APPLICATION NO: 21/00097/FUL/ADDINF
DESCRIPTION: Erection of single storey rear extension.
LOCATION: 21 Holbeck Bracknell Berkshire

29 HOLBECK  
FLOORPLAN AS PROPOSED  
SCALE 1:50

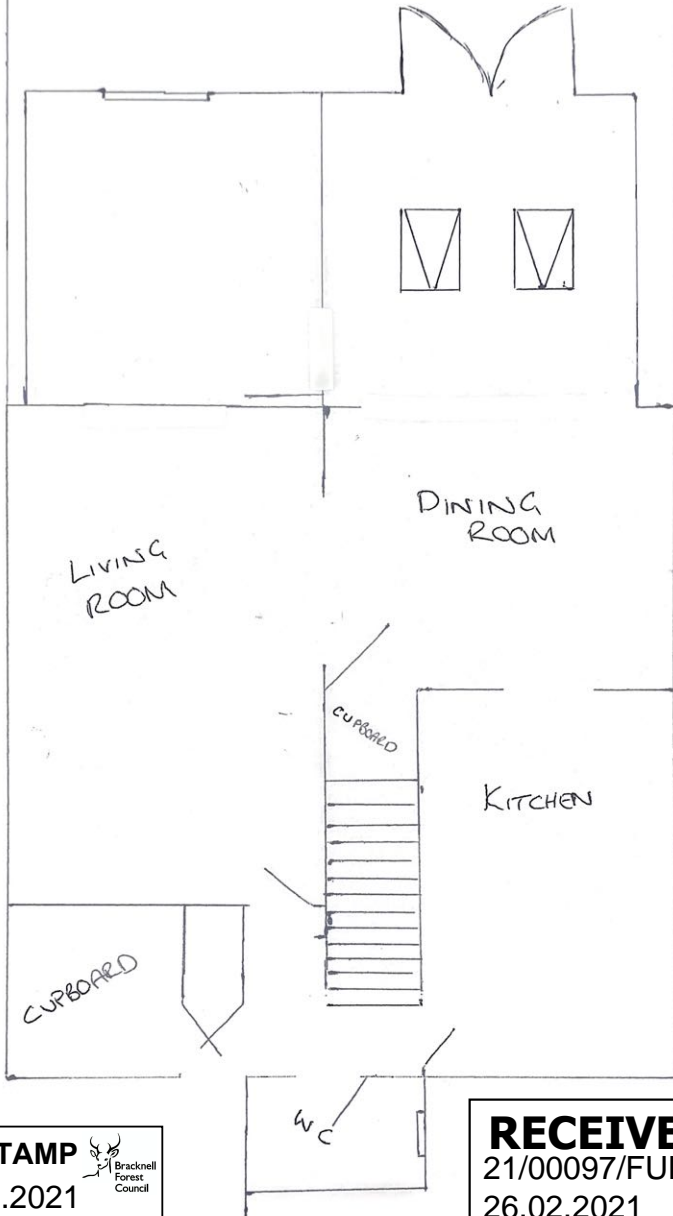
- 1 Please can you change the red line on the site location plan @1:1250 to surround the front of the property to the edge of the footpath and not just around the front porch. Also please show the extension on the 1:500 block plan accurately plotted. We also require existing and proposed floor plans.
